Our Reference: SYD20/01320/06

Departments Reference: SSD-11070211

**EXHIBITION OF EIS - NEW PUBLIC SCHOOL IN MULGOA RISE - 1-23 FORESTWOOD DRIVE
- GLENMORE PARK**

1 CAR PARK PLAN 01
1 : 200

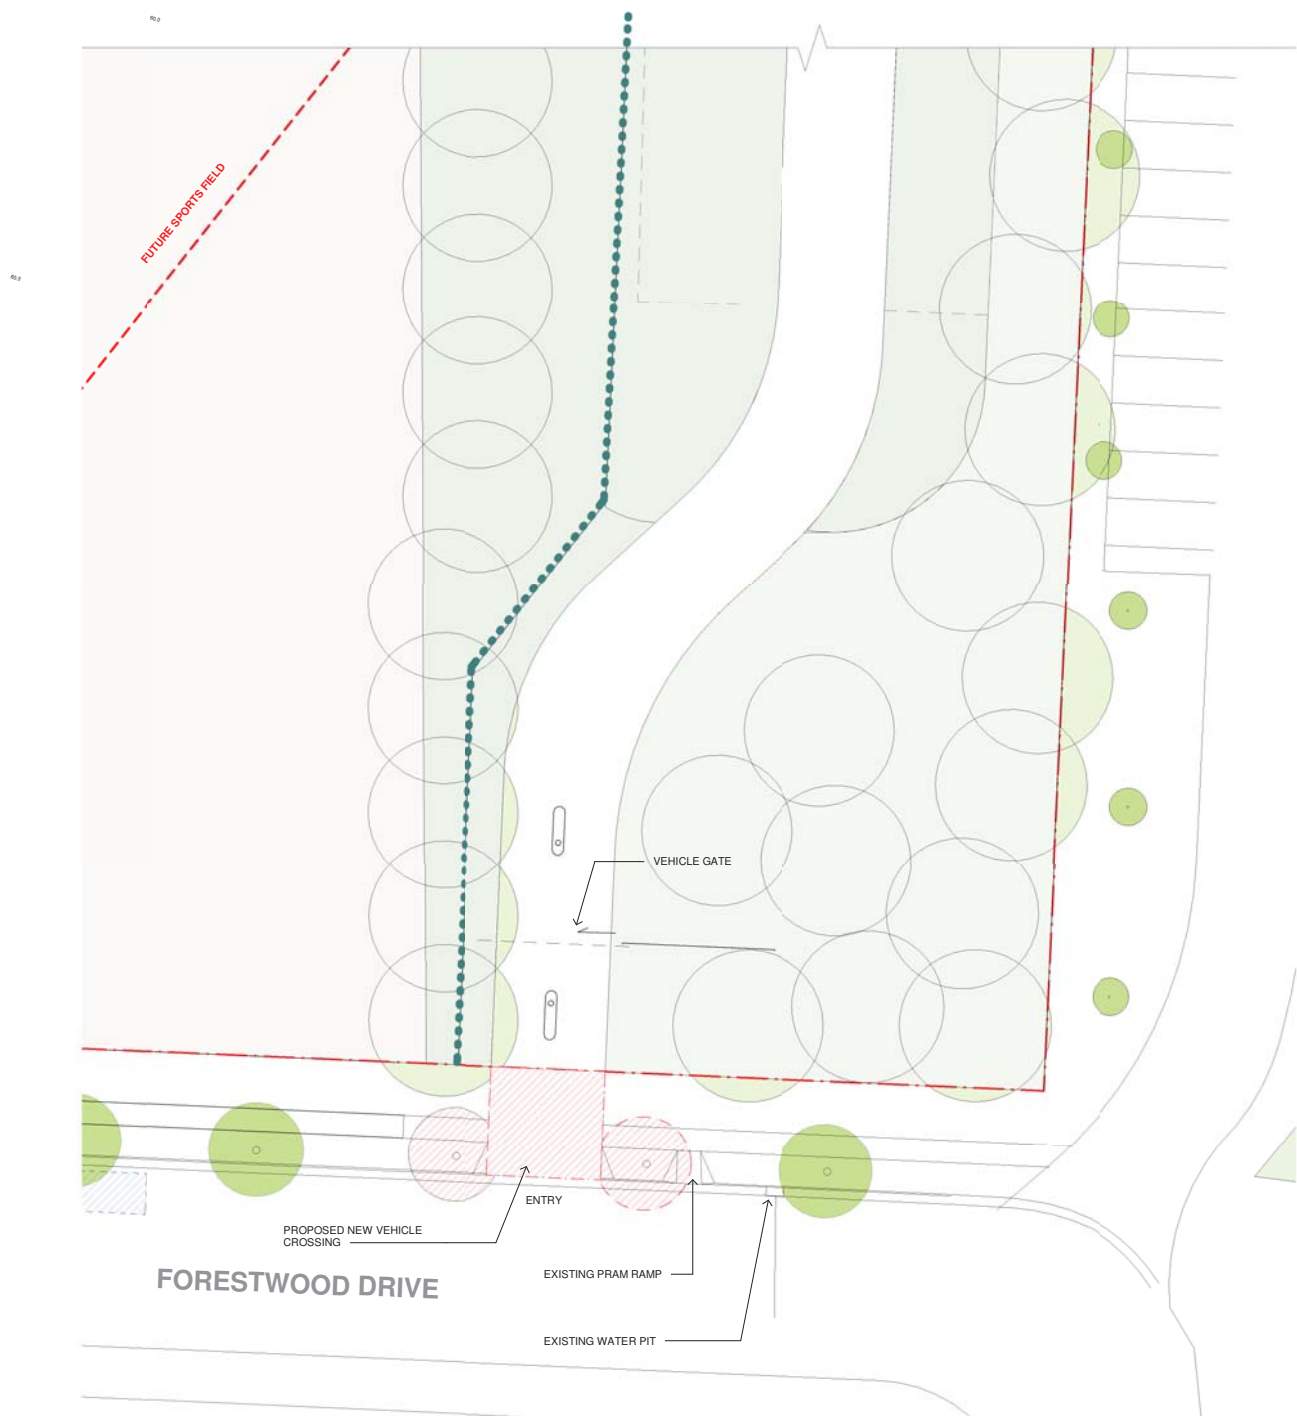
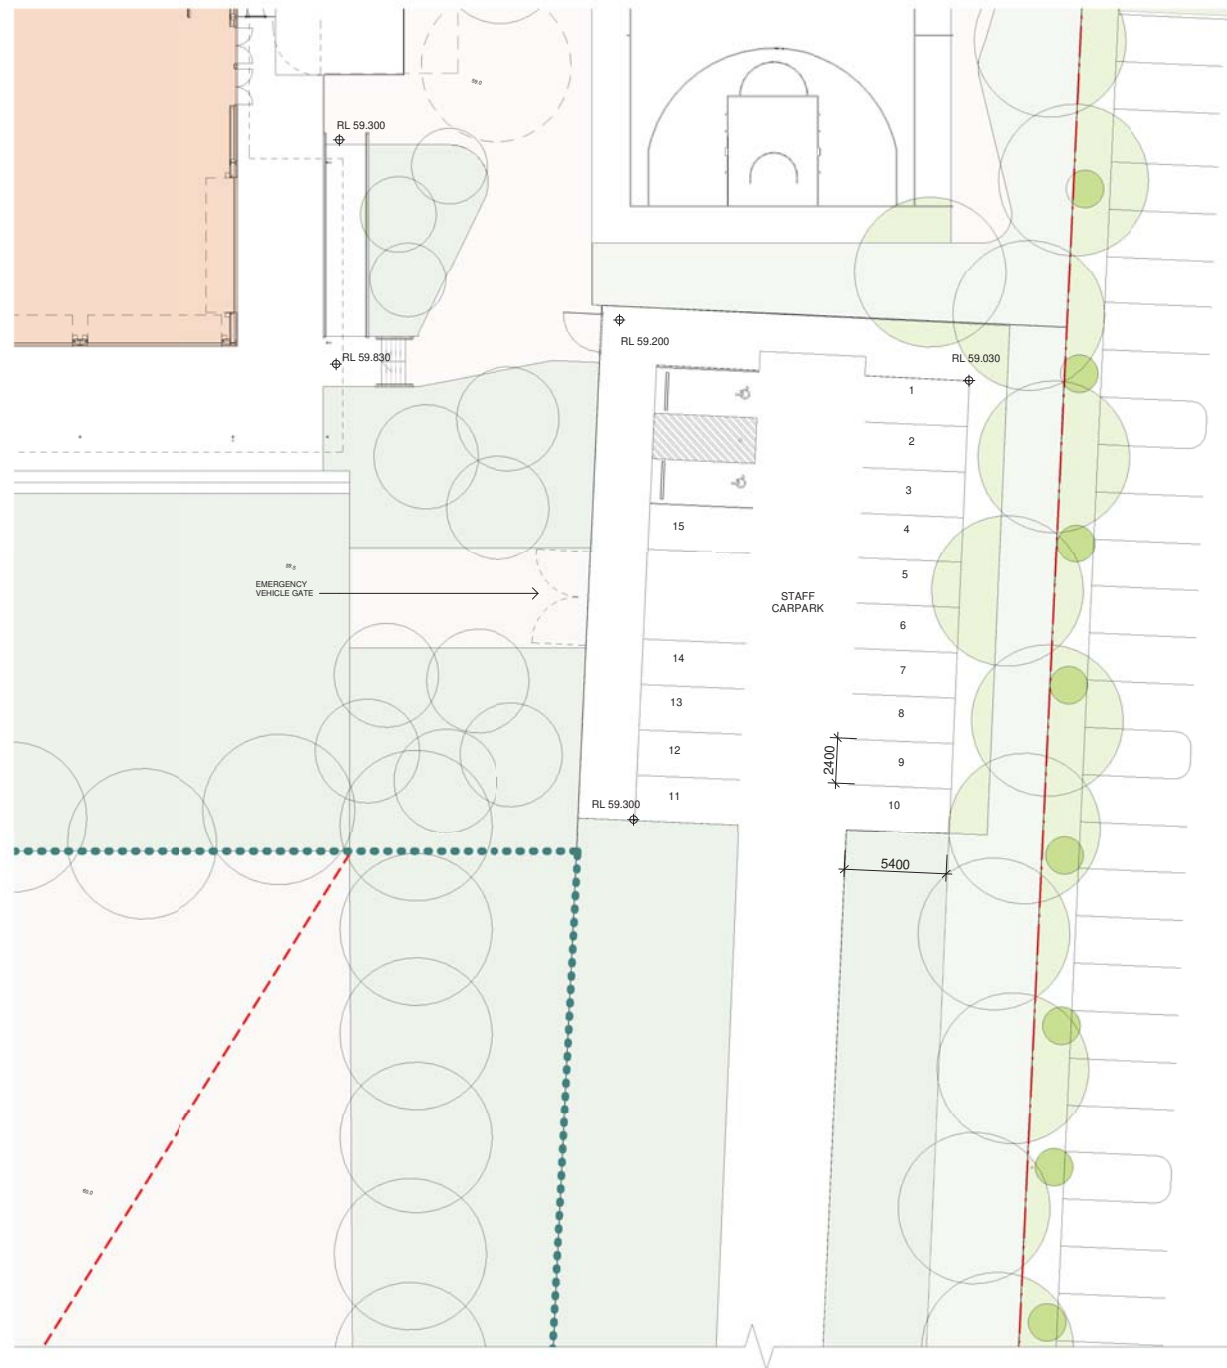
- n. Attachment 2 (Car Park Design review ptc-004) – right turn movements into car park should be reviewed as to whether sight distance to oncoming vehicles from north is sufficient. Parking spaces adjacent to driveway should also be removed to enable sight distances for vehicles leaving the driveway;

PICK UP & DROP OFF  
15 MINUTES PARKING  
& PEDESTRIAN SAFETY

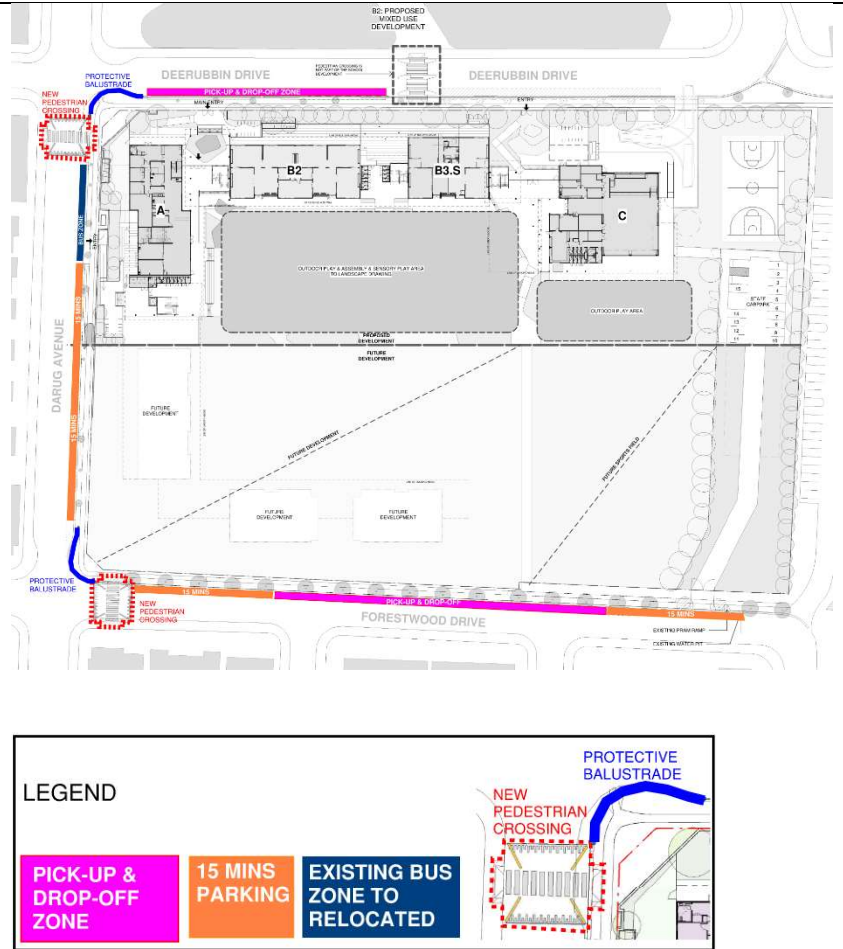
- b. 5.1 - The amount of parking spaces shown in Figure 41 will need to be revised as the below minimum buffer is required at zebra crossings;

- c. 5.2.5 – TfNSW questions whether the school drop off/pick up on Deerubbin Drive is going to attract more parents given the proximity to the school buildings, Especially during wet weather days.

TfNSW would not encourage school drop off/pick up or 15min parking for school days along Deerubbin Drive especially due to the proximity to the basement access of the mixed used development opposite the school. Given the narrow road at Deerubbin Drive, kerbside parking for school drop off and right turning vehicles into the mix used development would likely cause queuing and put pedestrian at risk when crossing Deerubbin Drive especially for vulnerable children crossing the road;
